A1 in Northumberland: Morpeth to Ellingham

Scheme Number: TR010059

7.34 Applicant's Responses to Deadline 9 Submissions

Applicant's Responses to Deadline 9 Submissions

Figure 3 – Alternative Route B

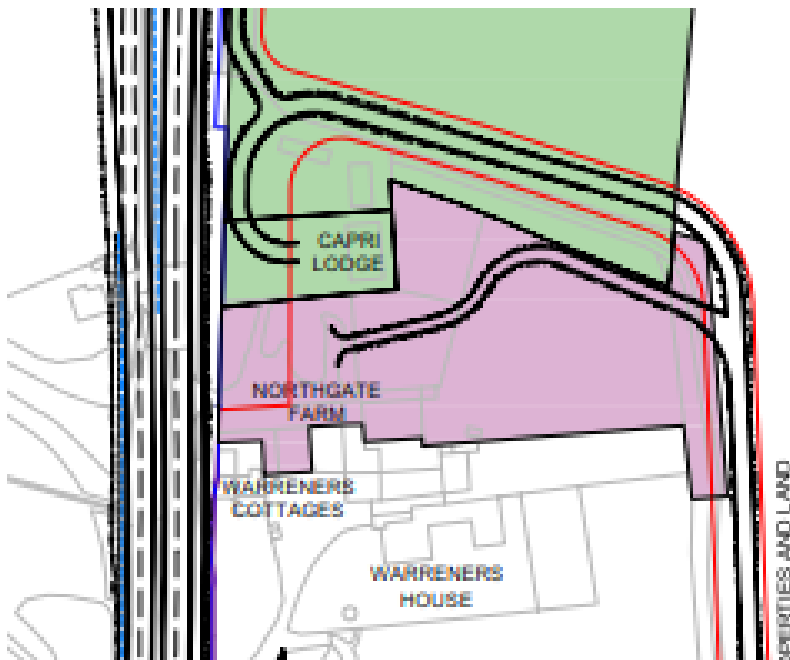
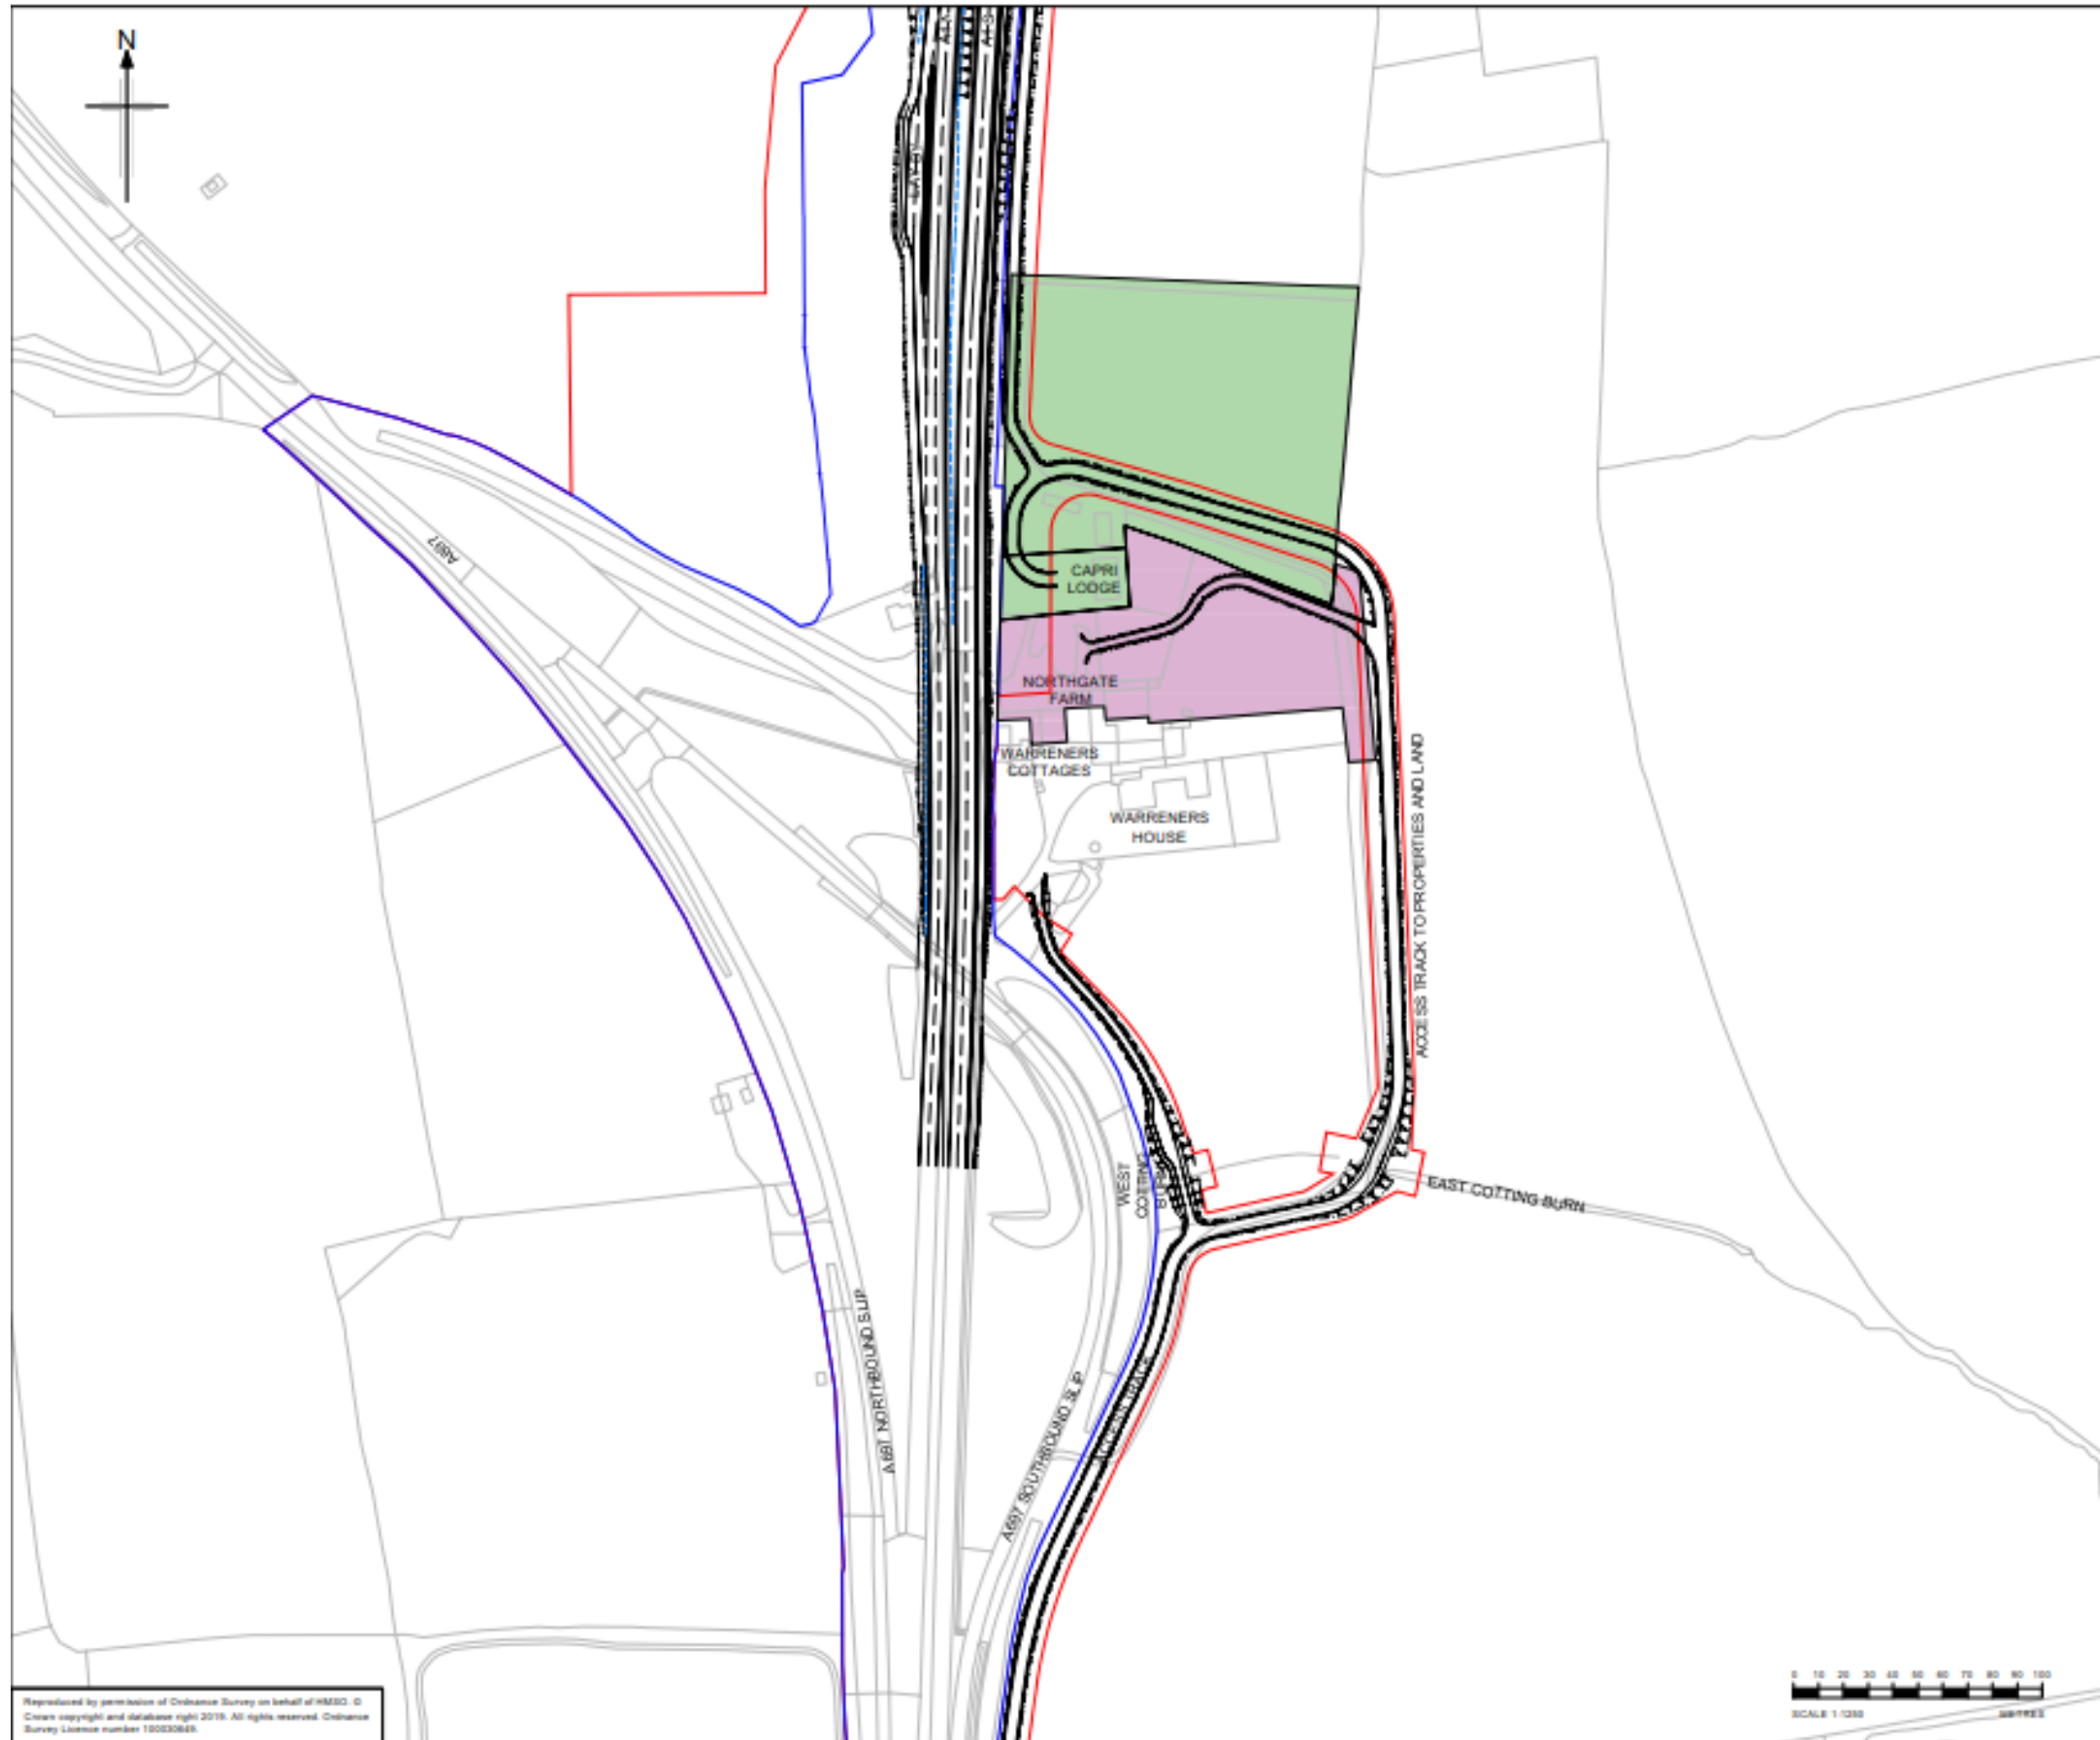
1	The additional access road would mean that we have two access roads running through our property within the woodland. The additional access road would significantly exasperate all the issues previously raised in respect to the woodland. This includes:	<ol style="list-style-type: none"> 1. The Applicant has previously responded to the points raised by Mr Hawes in relation to the loss of trees on the north east and eastern boundary to the garden. The Written Summary of Oral Submissions at Hearings – Appendix D – Warreners Private Means of Access [REP4-029] confirmed that the PMA will be predominantly constructed within plot 1/6a, and that plot 1/8a (owned by Mr Hawes) will primarily be used to install the new boundary hedgerow, fence and individual trees. 2. Appendix D goes on to set out how the Applicant will avoid the unnecessary removal of trees and outlines methods by which any remaining trees would be retained and protected, including measures to avoid impacts on root zones. The construction of the portion of Alternative Route B outside the Order limits would be the responsibility of Mr Hawes, but the Applicant would apply the methodology set out in Appendix B to the bell mouth and any other associated works within the Order limits.

A	Privacy	<ol style="list-style-type: none"> 1. Alternative Route B would pass through the small block of woodland to the east of Mr Hawes' property and would require additional trees to be removed. This would result in views from the PMA and access point being marginally more noticeable, although users of the PMA would remain those individuals accessing Northgate Farm, Capri Lodge and the fields to the north and the overall magnitude of visual impact would not change from that reported in Chapter 7: Landscape and Visual Part A [APP-044]. 2. Nevertheless, the Applicant remains committed to providing a boundary hedgerow around the eastern and northern perimeter of the garden space, which would provide screening to the garden space once established. This is identified on Landscape Mitigation Masterplan Part A

2	The construction of the additional tarmac road, stretching the length of Northgate Farm property (estimated at 135 metres), significantly adds to the amount of tarmac on view.	<p>1. The design and surfacing of the access within Mr Hawes's land would be his responsibility, and there is no reason to suppose (other than that he himself may prefer such surface a treatment) that it would comprise a tarmac road.</p> <p>2. The proposed access via Alternative B would impact directly upon the garden space and may change the way in which the occupants' access and make use of their garden space, as a result of the views of the access road. Alternative B would be visible from the north facing elevation of the dwelling, and the wider garden space to the east. However, the existing vegetation associated with the previously proposed access point would be retained, and as such the awareness of the Scheme to the</p>

4	The road through Northgate would take up a significant percentage of the property imposing constraints on how the property could be used in the future.	<ol style="list-style-type: none"> 1. Discussions as to any compensation payable for land impacted by the proposals will continue between the landowner/their professional representatives and the District Valuer, on behalf of the Applicant. However, the quantum of compensation is not a matter for the Examination. 2. It is important to recognise that there would be no loss of land as a result of either Alternative A or Alternative B. Furthermore, in each case its provision would be because Mr Hawes had requested it.
5	The road would partition the property leaving areas of dead space which would not be utilised.	<ol style="list-style-type: none"> 1. It is not accepted that the property would be "partitioned". The north eastern corner plot of 1/8b would adjoin the portion of Alternative Route B within Mr Hawes' property. It would still be able to be accessed by Mr Hawes. 2. The treatment and use of these areas are not required or precluded by the Scheme, and it will be for Mr Hawes to use them.

6	The road creates additional burden and responsibility on the property for maintenance.	<ol style="list-style-type: none"> 1. Either of the alternative routes would be substituted for the DCO application PMA route, which would also have maintenance responsibilities for the relevant landowners. In the case of the DCO application PMA route, there would be a standard provision for the landowner of each section of the proposed PMA to be liable for its maintenance. This would be simplified if substituted for one of the alternative routes. It is anticipated that a commuted sum for any additional future maintenance liabilities could be agreed with each relevant party by the District Valuer, on behalf of the Applicant. 2. The manner of construction of Alternative A or Alternative B is a matter for Mr Hawes, who would also be responsible for its maintenance.

Ref. No.	Response:	Applicant's Response:
7	The road would require a significant amount of additional land works and landscaping. This would include managing septic tank and water pipes which fall within the route of the road. The well-established vegetable garden would also need to be re-positioned.	<ol style="list-style-type: none"> 1. The Applicant is cognisant of Mr Hawes' concerns as to the work required outside the Order limits. Alternative Route B is one of two alternative solutions requested by the two affected parties in lieu of the current DCO proposal, which the Applicant has assessed and mitigated. 2. As confirmed on page 2 of Northgate Farm Private Means of Access Options Technical Note [REP8a-005], the Applicant would support the affected landowners in obtaining planning permission for this element of the access, outside the DCO process.
Section 2 Current Proposal		
	As previously documented in detail the current proposal is not a good solution and has a number of major issues, which we recognise cannot be resolved. This includes, but not limited to:	<ol style="list-style-type: none"> 1. The Applicant has assessed the environmental impacts of the proposed Scheme layout, including the Warreners PMA, and has proposed appropriate mitigation for those impacts in accordance with the relevant topic-specific guidance. In doing so, the Applicant has taken account of the concerns raised by interested parties such as Mr Hawes, both prior to Application and during the course of examination. 2. The Applicant's previous responses to the concerns raised by Mr Hawes in relation to the Warreners PMA as proposed within the DCO application are set out in REP1-064, REP3-026, REP5-029, REP5-030, REP6-040, REP6-043, REP7-017 and REP9-018 and are not repeated in detail here.

Ref. No.	Response:	Applicant's Response:
		any additional future maintenance liabilities could be agreed with each relevant party by the District Valuer, on behalf of the Applicant.
Section 1.2.2		
	The Applicant is correct in highlighting that Alternative Route B does not require agreement between the parties but does not recognise that it would require a major compromise, from Northgate Farm to resolve a problem that was not of its making. Although we were prepared to make compromises for Alternative A this option represents a much larger scale of concession, particularly with the impact upon the woodland. This includes the following:	<ol style="list-style-type: none"> 1. The impacts of Alternative Route B on Northgate Farm are set out at section 3.3 of [REP8a-005]. This concludes that Alternative Route B would result in no change to the conclusions of the assessments reported within the ES, Environmental Statement Addendum: Earthworks Amendments for Change Request [REP4-061], Environmental Statement Addendum: Stabilisation Works for Change Request [REP4-063], Environmental Statement Addendum: Southern Access Works for Change Request [REP4-064], Noise Addendum [REP1-019 to REP1-022], Air Quality Assessment (Scheme Opening Year 2024) [REP3-012] and Updated Biodiversity Air Quality DMRB Sensitivity Assessment [REP3-010]. 2. The Applicant's position remains that, in the absence of agreement between the affected parties in relation to the original proposal presented in the DCO application or Alternative Route A, the Applicant's proposal to the Examining Authority is that Alternative Route B should be taken forward as part of the Scheme.
